**WEST SUSSEX COUNTY COUNCIL
INFRASTRUCTURE CONSULTATION**

SUBJECT: FN/59/09

Winton Stores, The Square, Findon

Conversion of existing building to provide 2 dwellings

DRAWING TITLE
Plans, Elevations
& Sections as Proposed

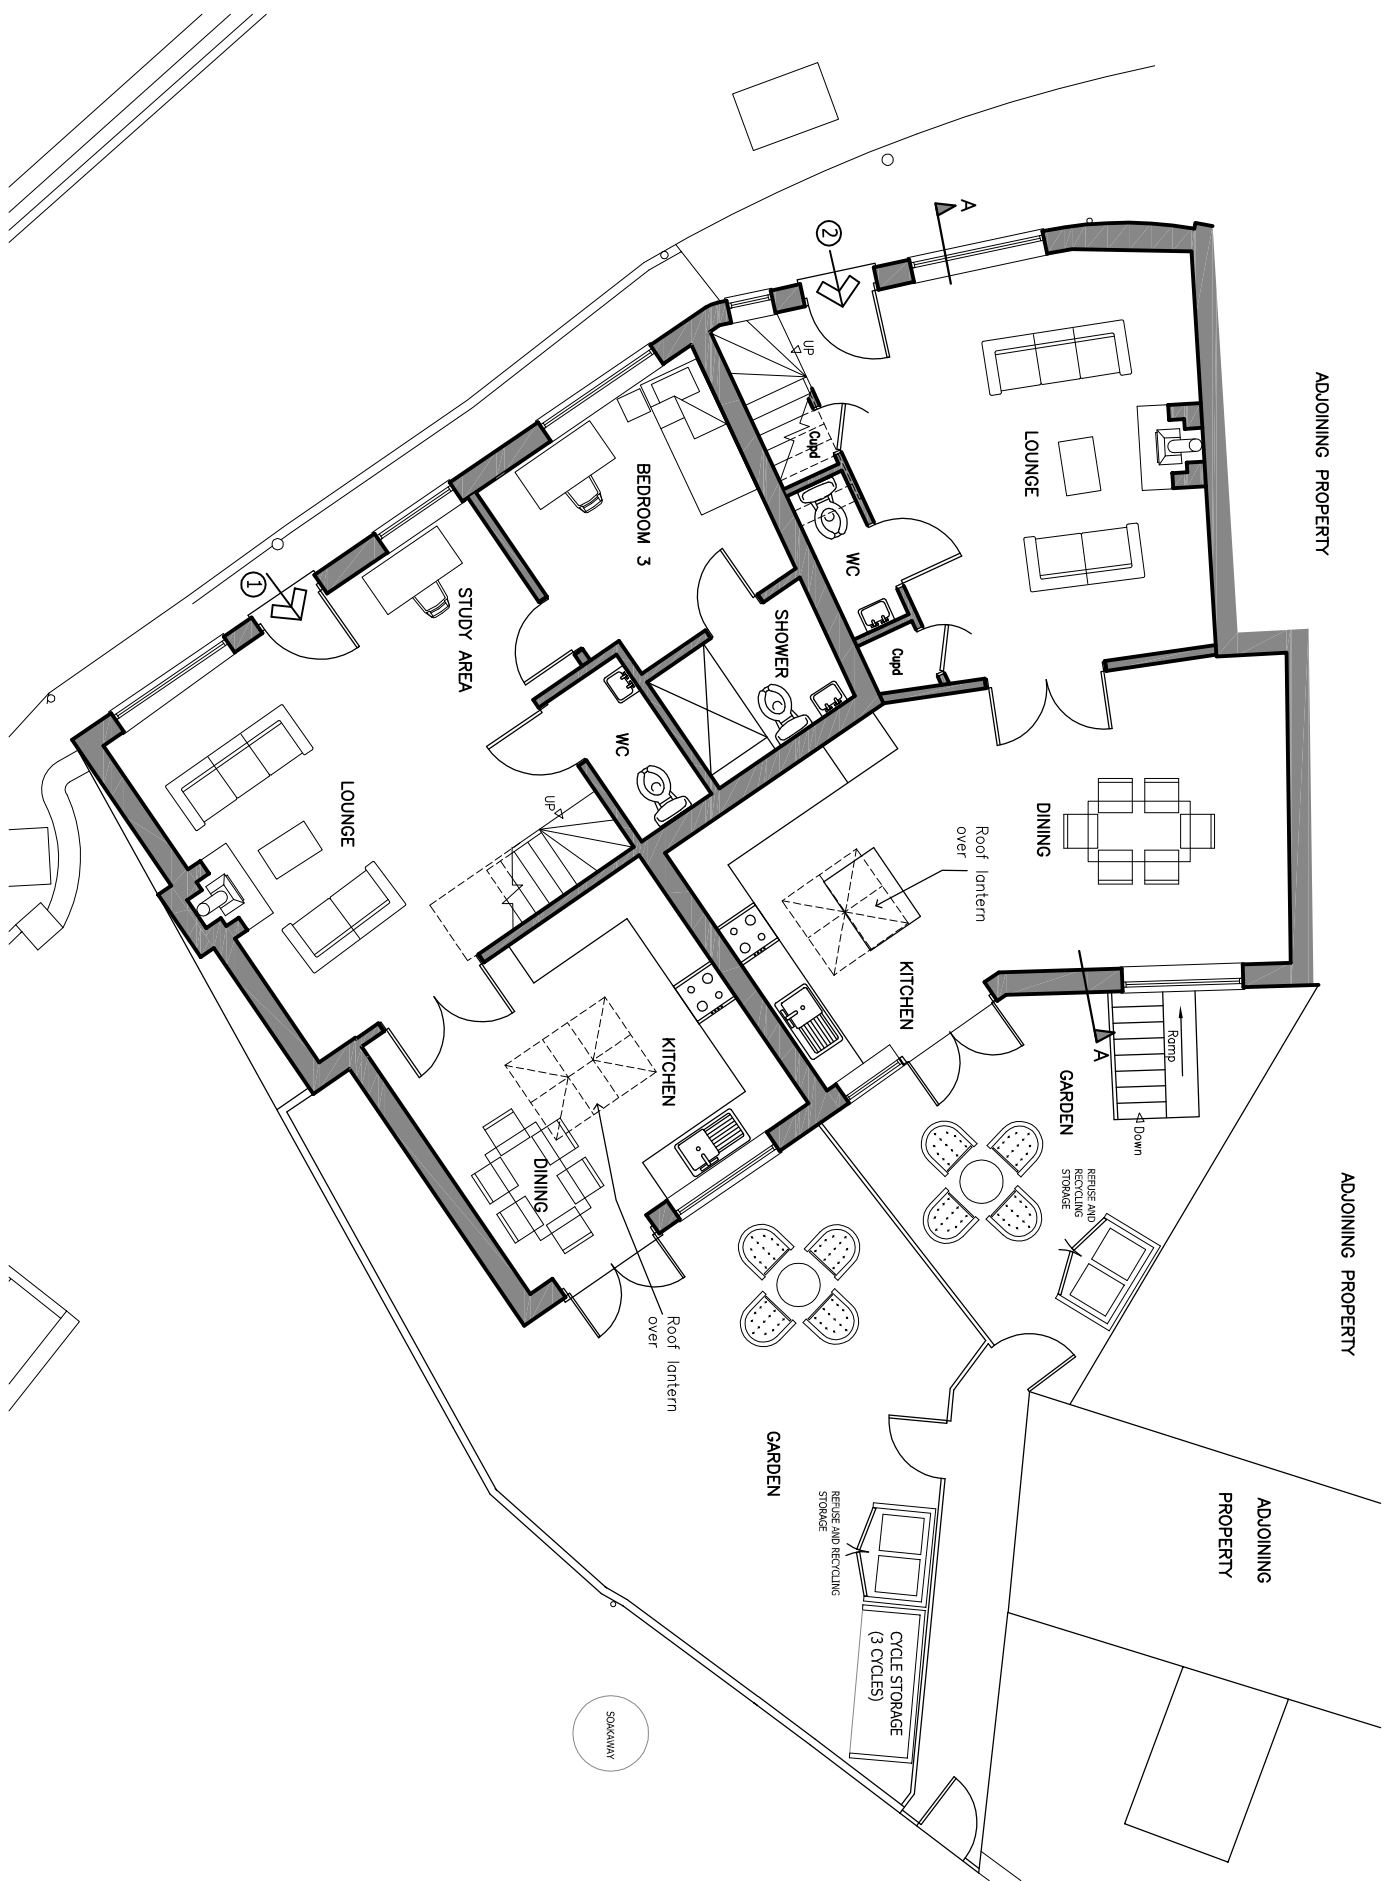
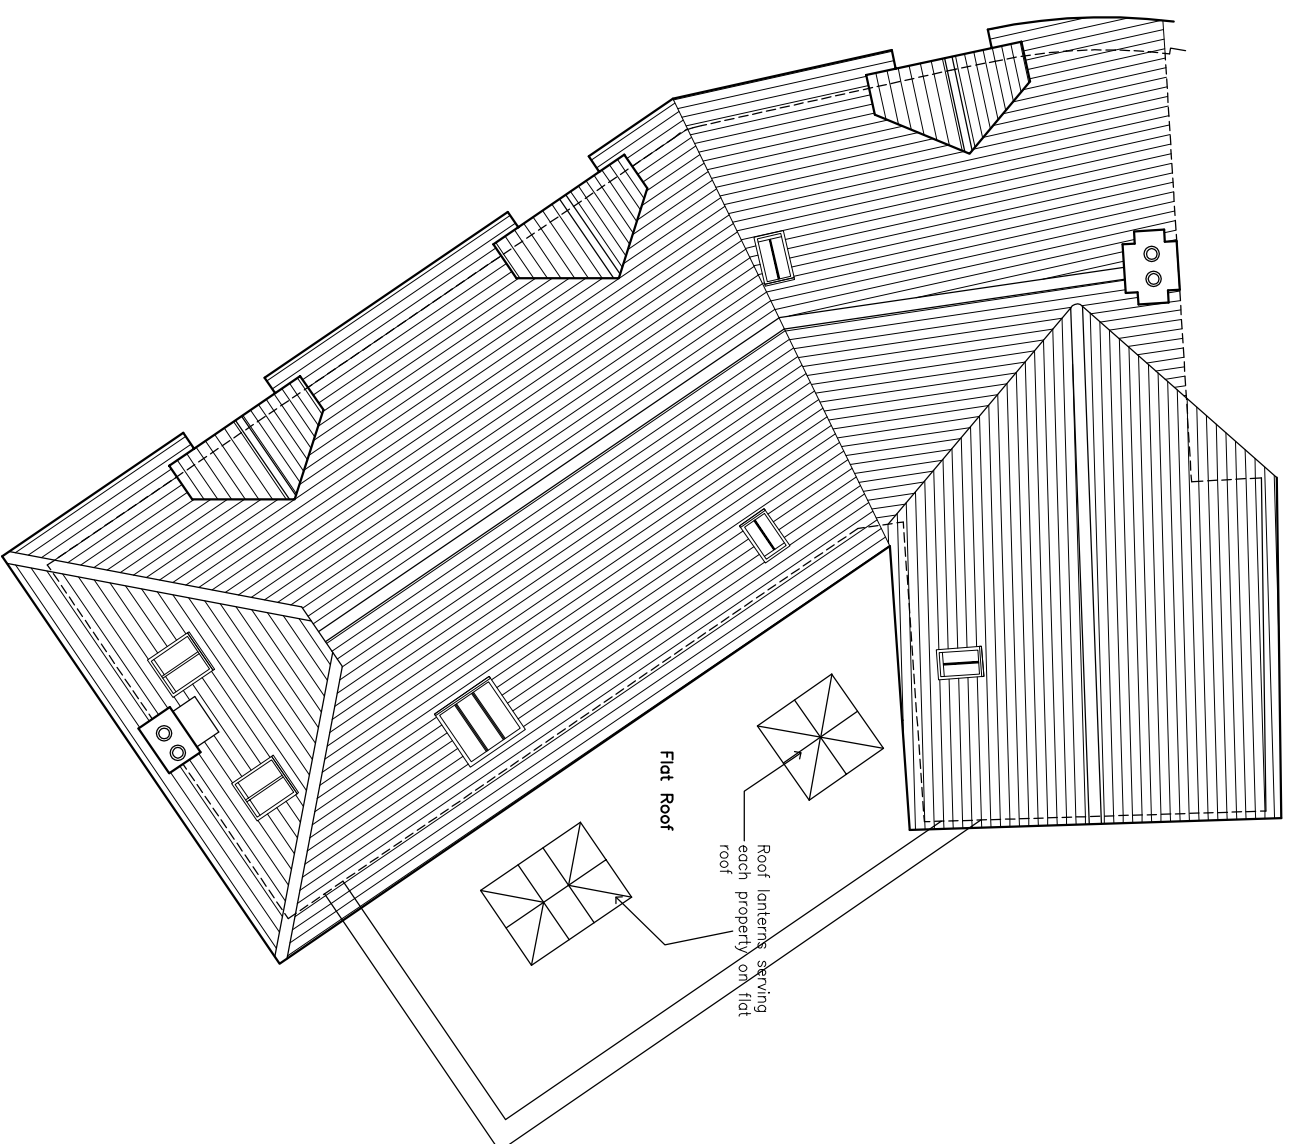
The proposal is for the conversion of an existing building to provide residential accommodation in the form of 2 dwellings. From an inspection of the plans alone, no vehicular parking has been provided to serve the new dwellings. The previous application was granted at appeal, with the inspector concluding that although the demand for car parking in this location may be high he observed at the time of his visit that parking provision was available in the adjacent row of spaces that front the green. The inspector also concluded that there was a lack of evidence to clearly demonstrate that it would be any different from the existing highway conditions and moreover that it would be harmful to highway safety.

Given that the highway arrangements have not significantly changed since these comments were provided, and as the proposal seeks to create less residential development, WSCC would not be able to support an objection to the lack of parking allocated to the dwellings on the grounds of highway safety.
